DECISION DELEGATED TO DEVELOPMENT MANAGER

Application No: H22-0070-19 **Applicant:** Seagate Homes (UK) Ltd

Proposal: Details of external materials, design and position of external boxes, gas flues and soil vent pipes, boundary treatment and Management Plan for Public Open Space (Conditions 4, 5, 7 and 8 of H22-0202-16)

Location: Land Off Dean Close/Small Drove Weston Spalding

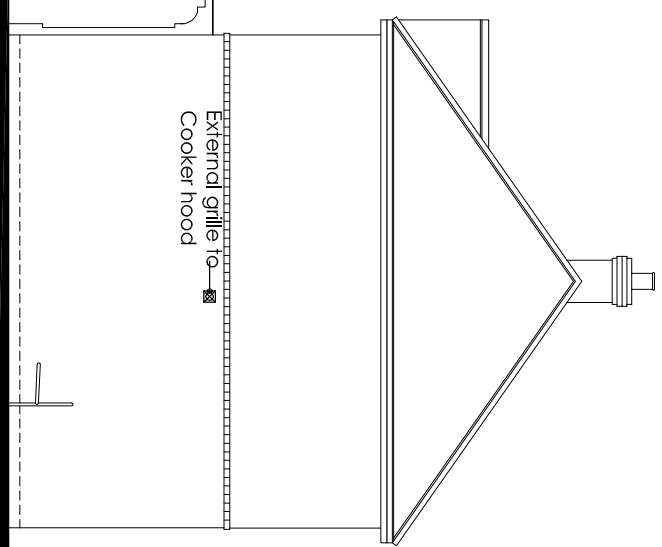
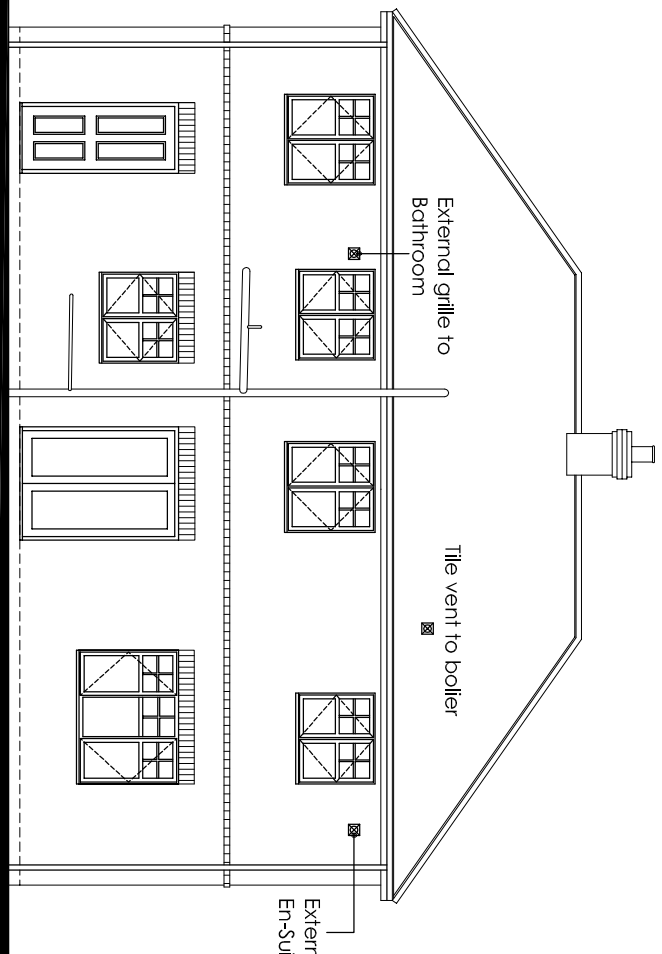
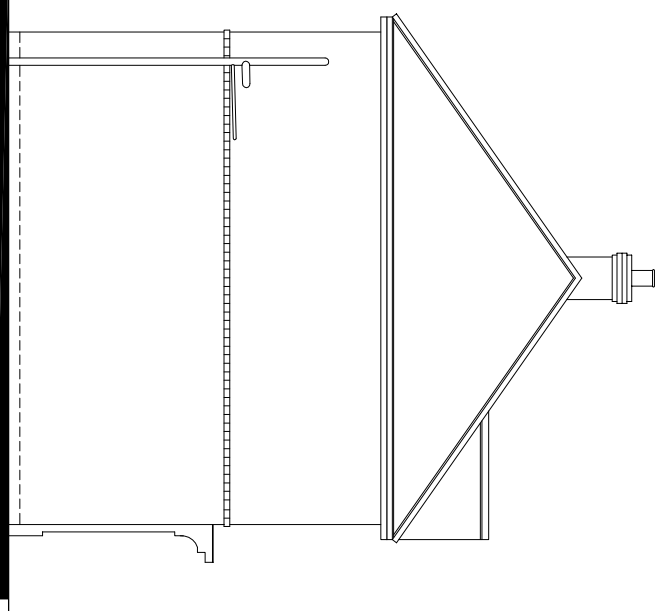
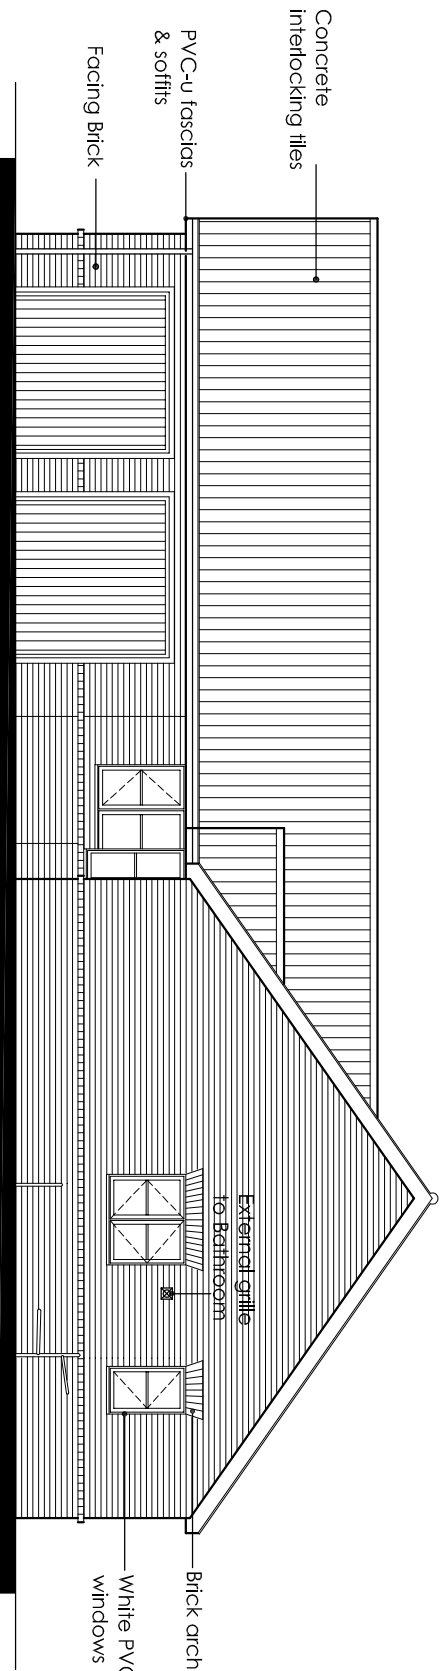
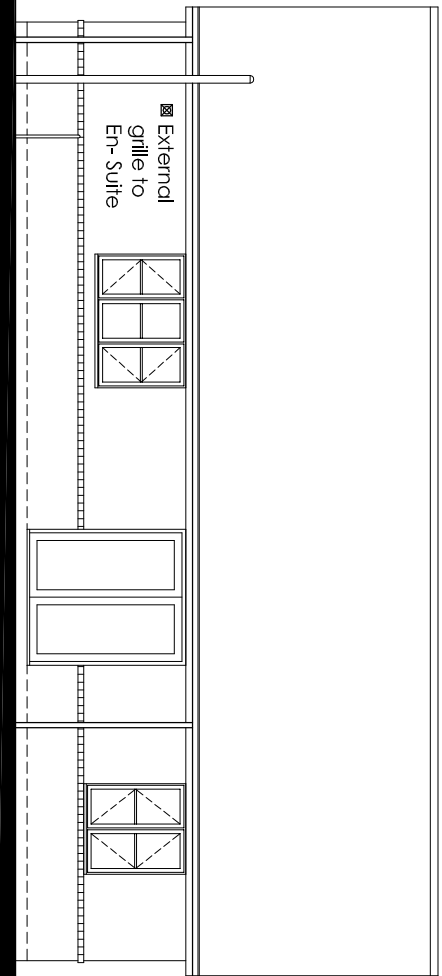
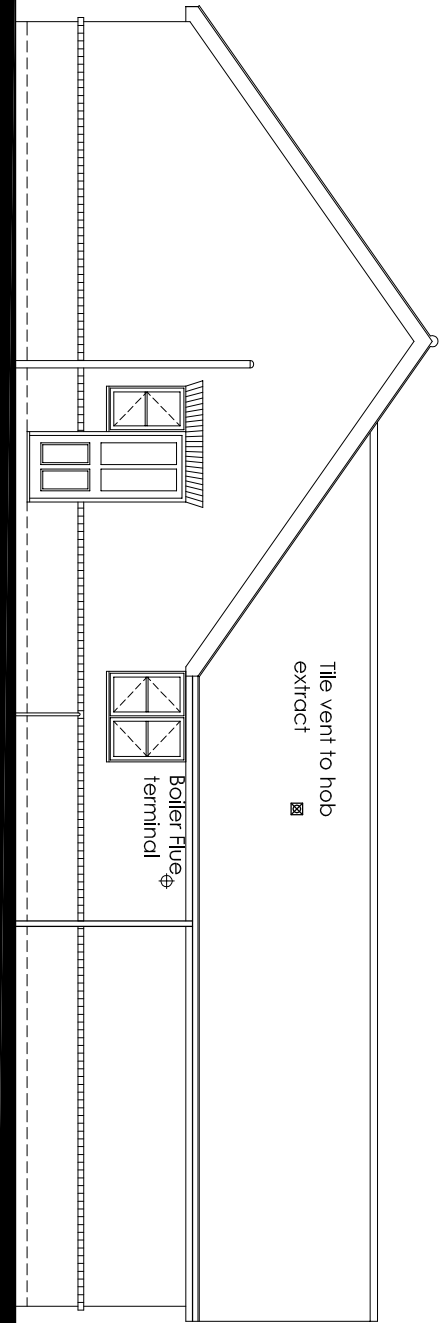
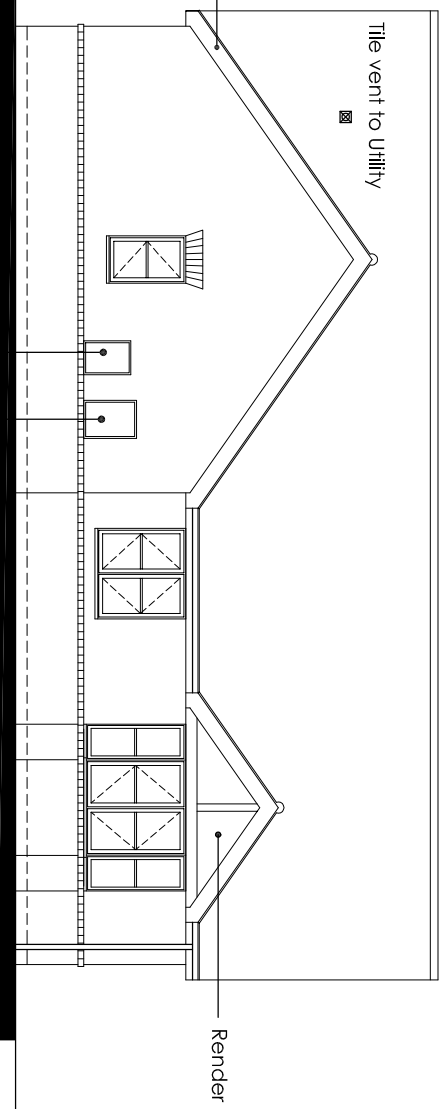
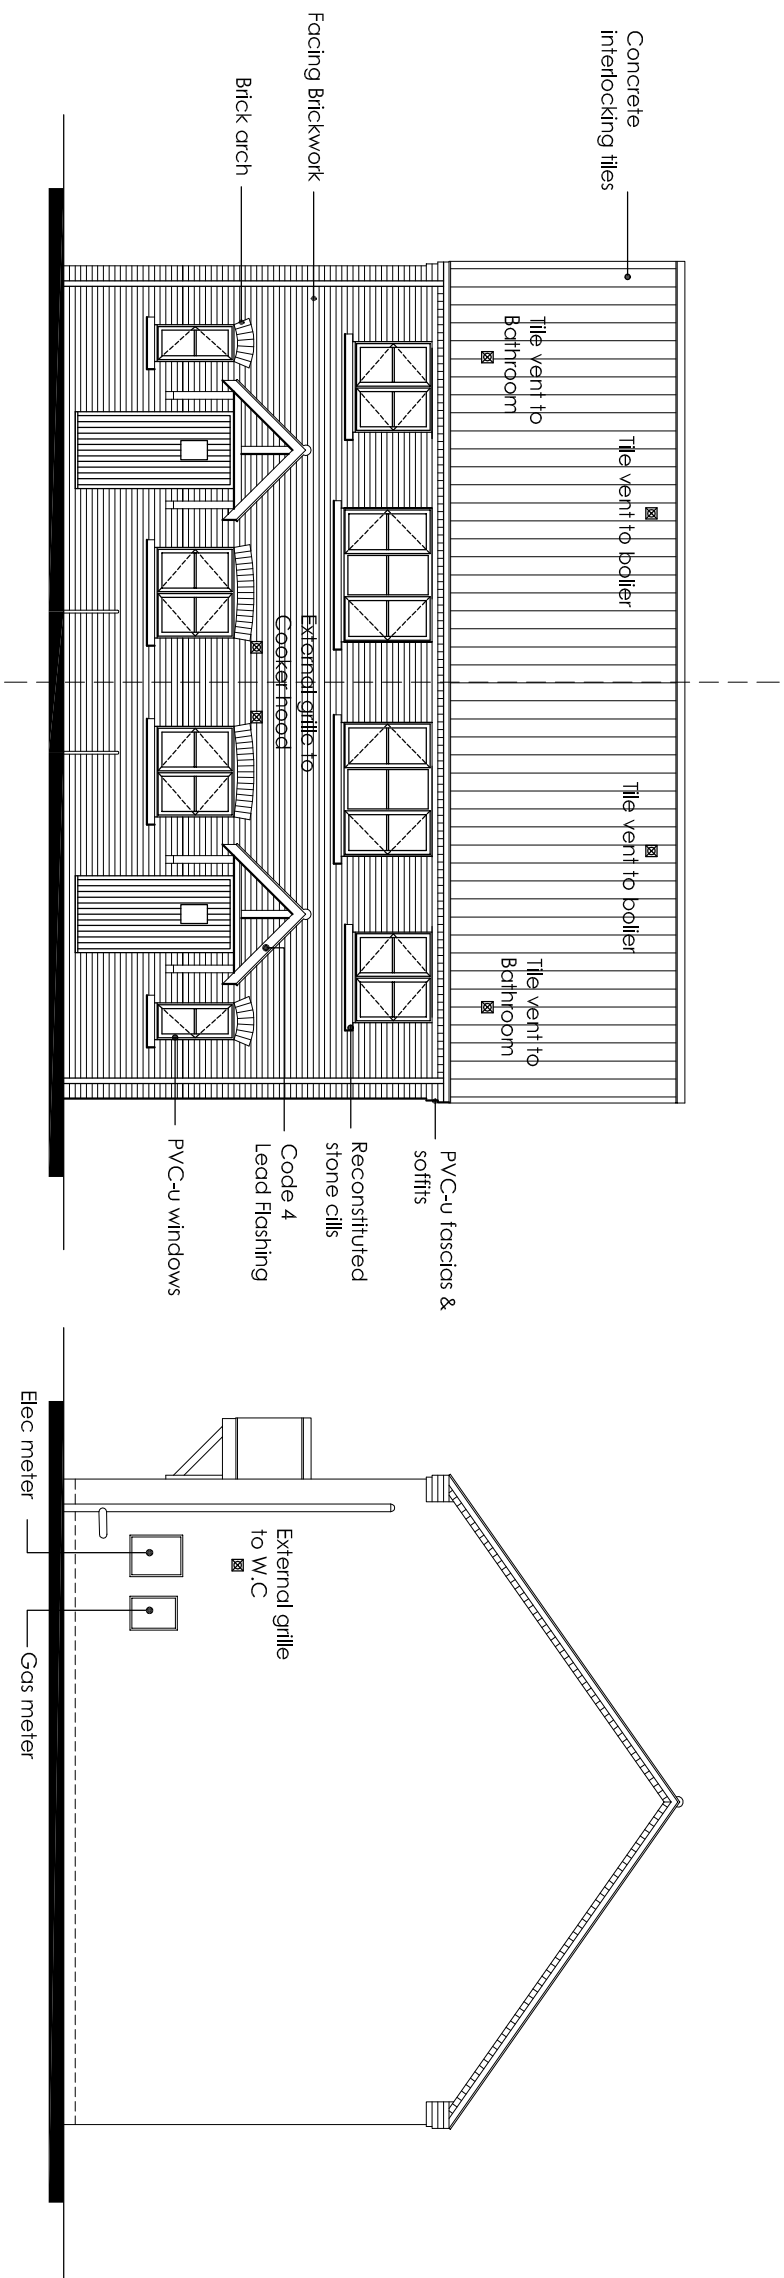
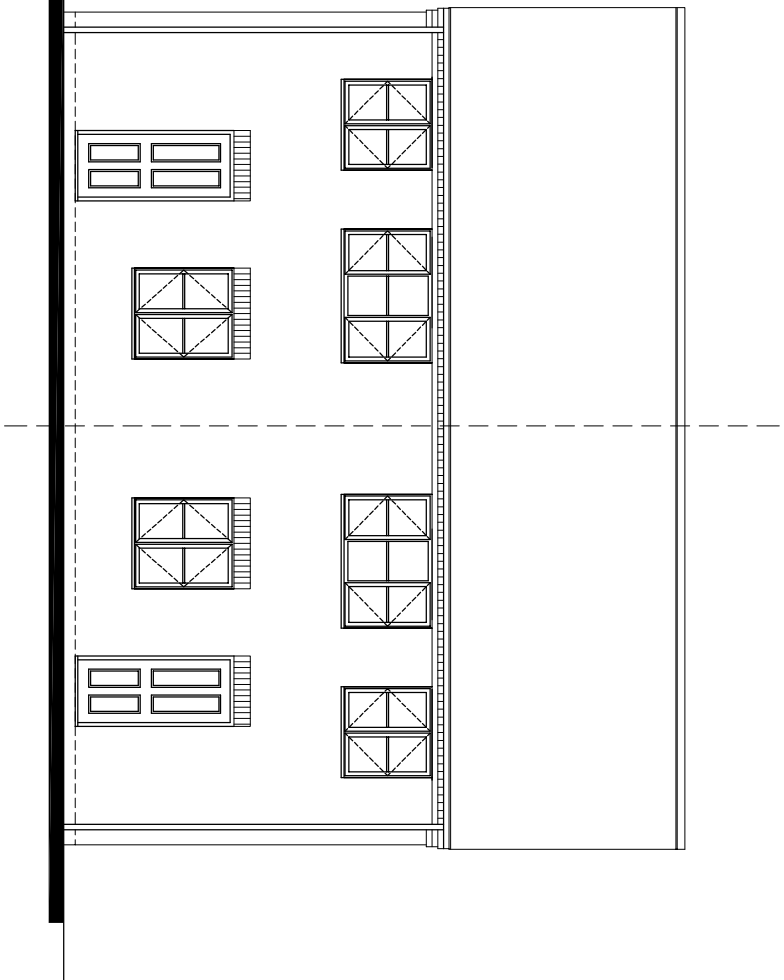
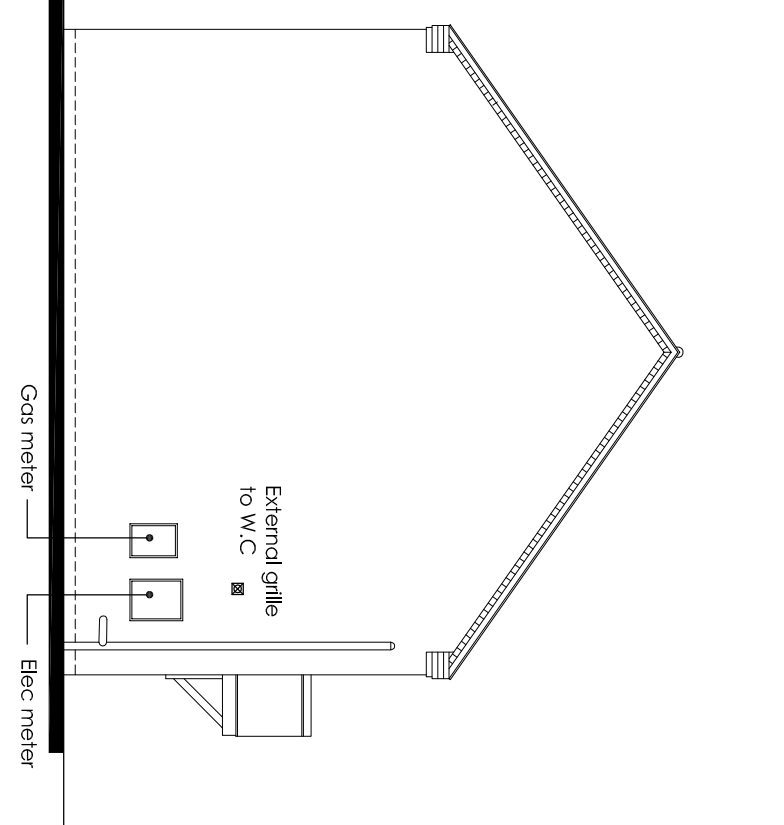
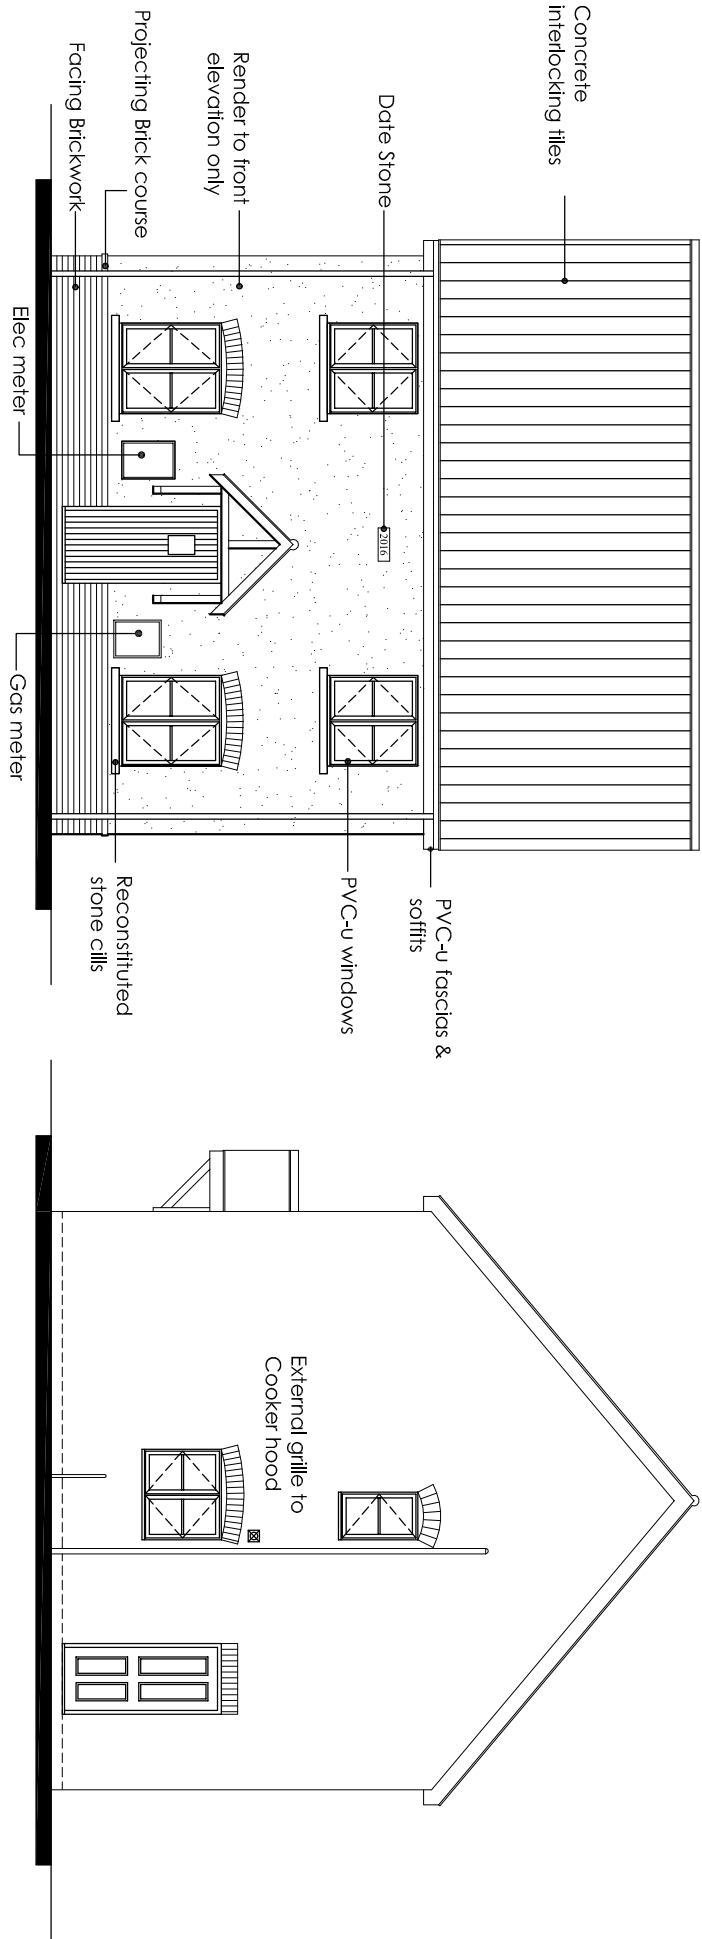
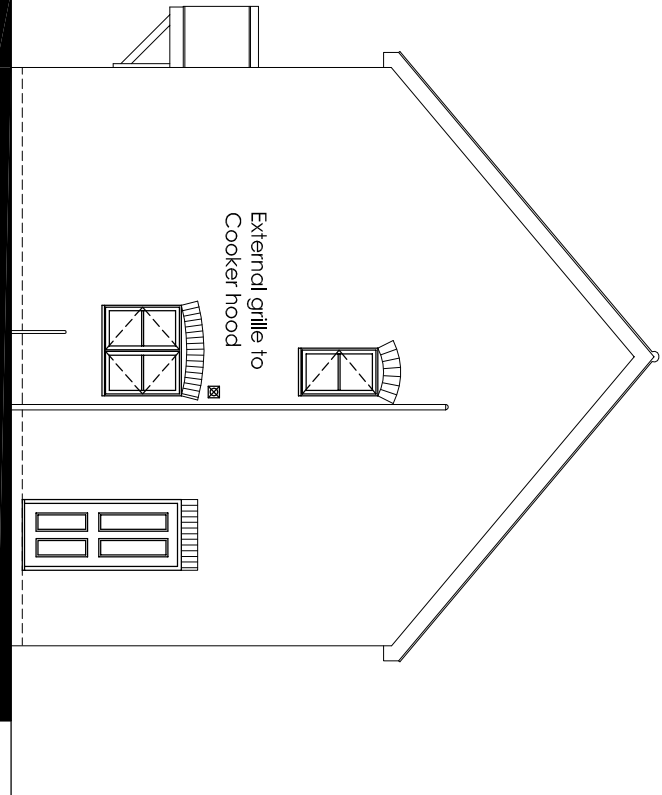
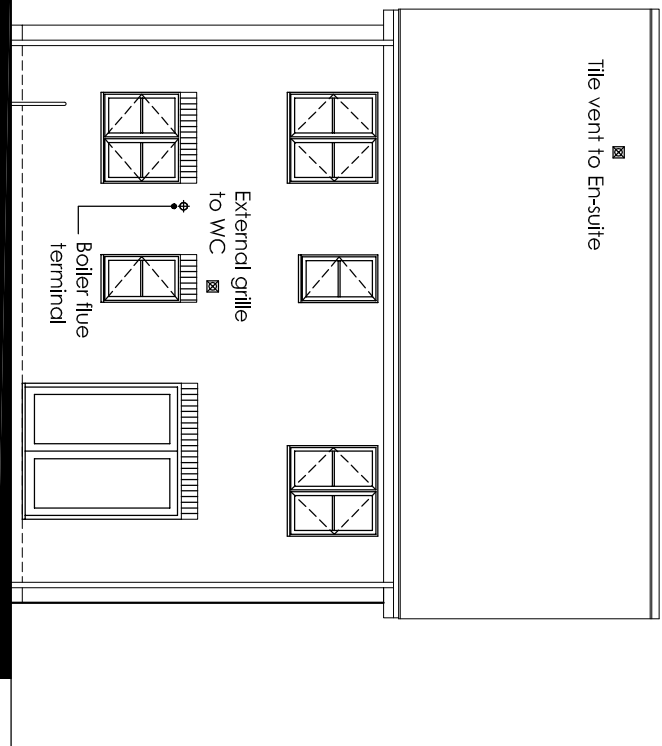
Amended elevation plans were requested to address the concern that a large number of meter boxes were on the front elevation of properties. These have been repositioned on side elevations where practicable or replaced with ground mounted boxes.
